## Site Compound Locations

Below shows the site compound plan from [APP-016] 2.5 Site Layout Plans and my property [REDACTED] and the site compound in question, within the green circle.

Drawing Title:
Height Parameter Plan - Sheet 6 of 16

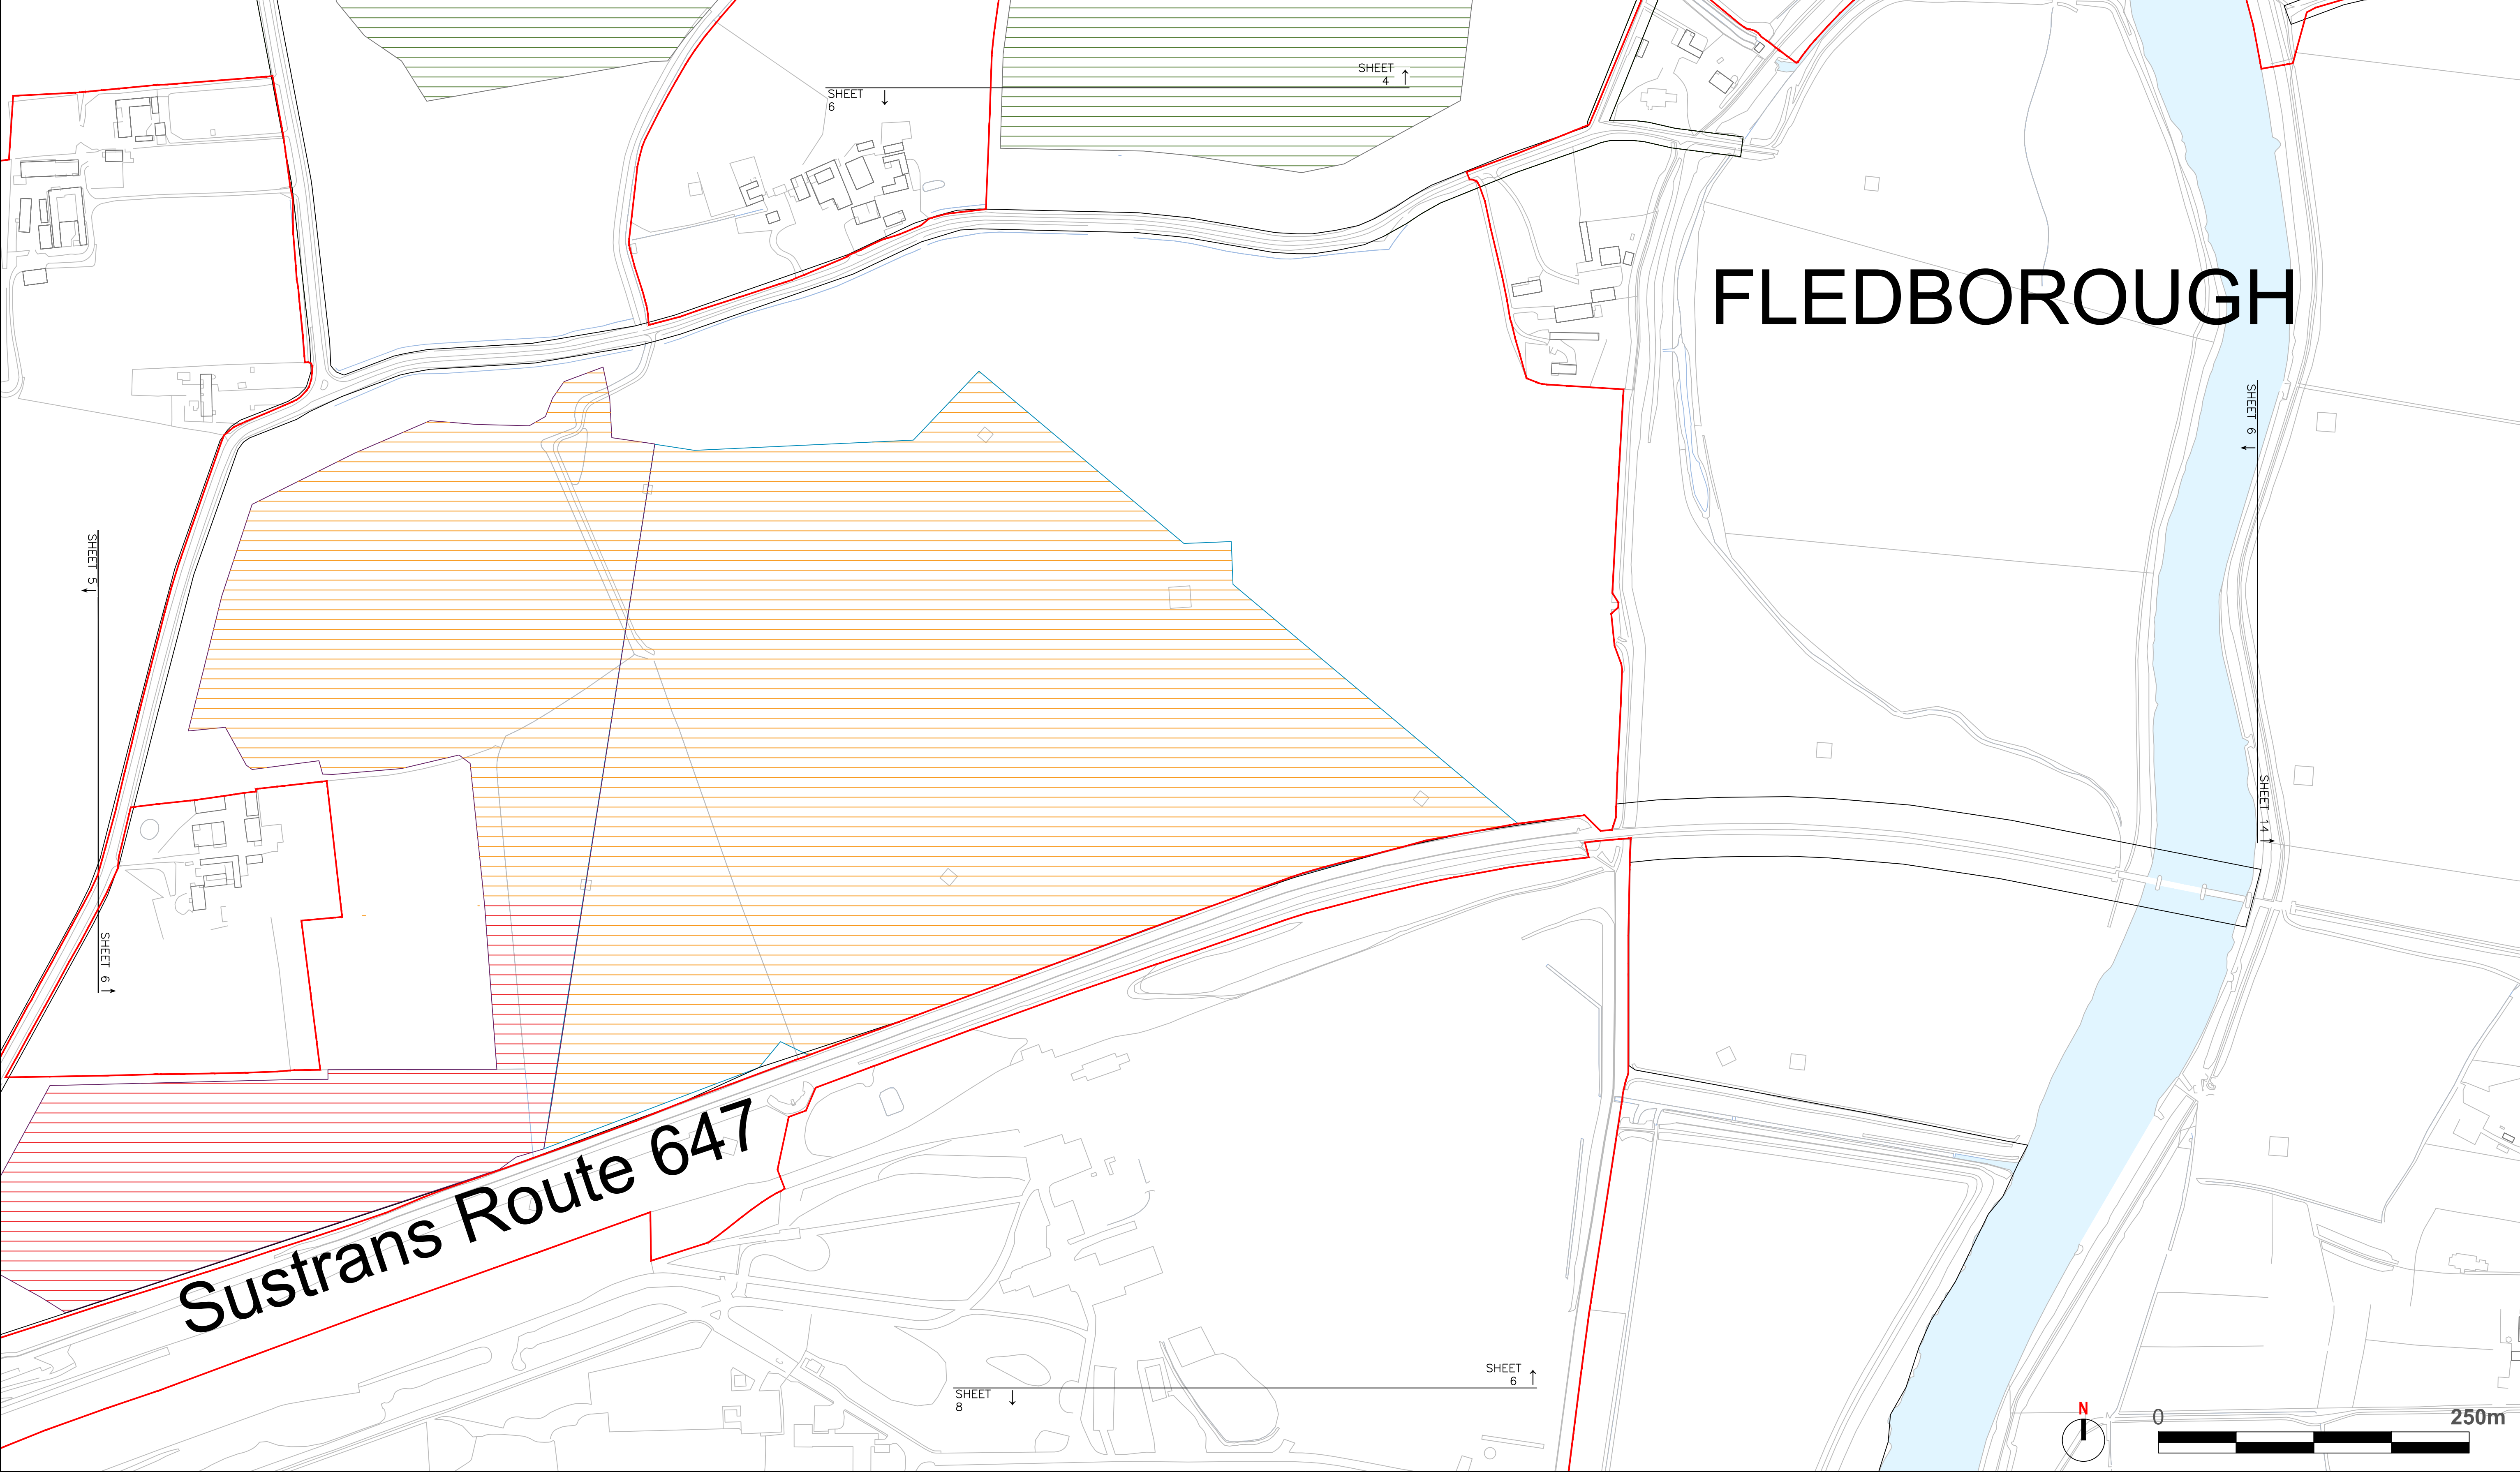
During consultation and site visits to my property [REDACTED], I raised specific concerns about the proposed placement of a site compound in close proximity to my home. The Applicant indicated that the location would be reviewed; however, no such revision has been made.

Given the scheme covers nearly 4,000 acres, it is unclear why the Applicant considers it necessary to position a site compound so close to my family home. The chosen location will be highly visible every time we arrive at the property and when attempting to enjoy the visual amenity of our home and its immediate surroundings.

This compound is also located adjacent to the Sustrans route, meaning its adverse effects will extend beyond residents to all users of this well-used public route.

I respectfully request that the Applicant reconsider the placement of this site compound and identify a less intrusive location.
